| PROPOSAL: Reserved matters application for residential development pursuant to outline permission 2016/91337 | Ref. No. | GG141 |
| LOCATION: land at, former St Luke's Hospital, Blackmoorfoot Road, Crosland Moor, Huddersfield, HD4 5RQ | Date Received | 17/10/2018 |

NOTES/COMMENTS

Landscape ref: GG141

TITLE: **Planning Layout**

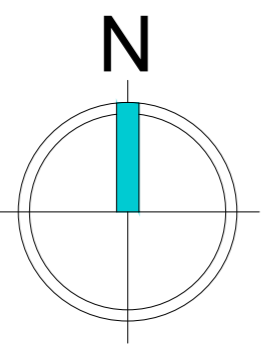
The landscape planting does not indicate much street tree planting, even though this is a key point in the D&A statement – highlighted below:

- Details for disposal of any waste arising from works
 - Confirmation in s106 of the provision of offsite lump sum
2. The Council considers a presumption in favour of tree planting in verges and adjacent to carriageways in line with the West Yorkshire Combined Authority 'Green Streets ®' principles, unless there are valid reasons for their omission. Tree planting is very important, and getting the right types and size of trees in the right places is imperative. Trees should be incorporated in the scheme for a variety of reasons: to a] visually break up the built form b] help to screen/ mitigate or frame certain views c] support biodiversity and create green corridors/green links, d] not to create a nuisance in peoples gardens through leaves in gutters or screen the sun etc. e] not to cause damage to property boundaries/garden fences/dry stone walls in the future, or damage any SuDS system. There are opportunities for tree planting within the site and this will help mitigate the scheme.

3. The scheme should consider how trees and street lighting should be specified together to avoid tree canopies from obstructing large amounts of street lighting and also provision of a maintenance schedule for trees to ensure safe levels of lighting at street level once trees mature.

4. The scheme will need to demonstrate clearly where bin storage AND collection points are, each dwelling will require 2 no. containers- at least 1 x 240ltr grey & 1 x green 240ltr. Also indicate the location of proposed grit bins. It is important that a functional facility for refuse collection is included.
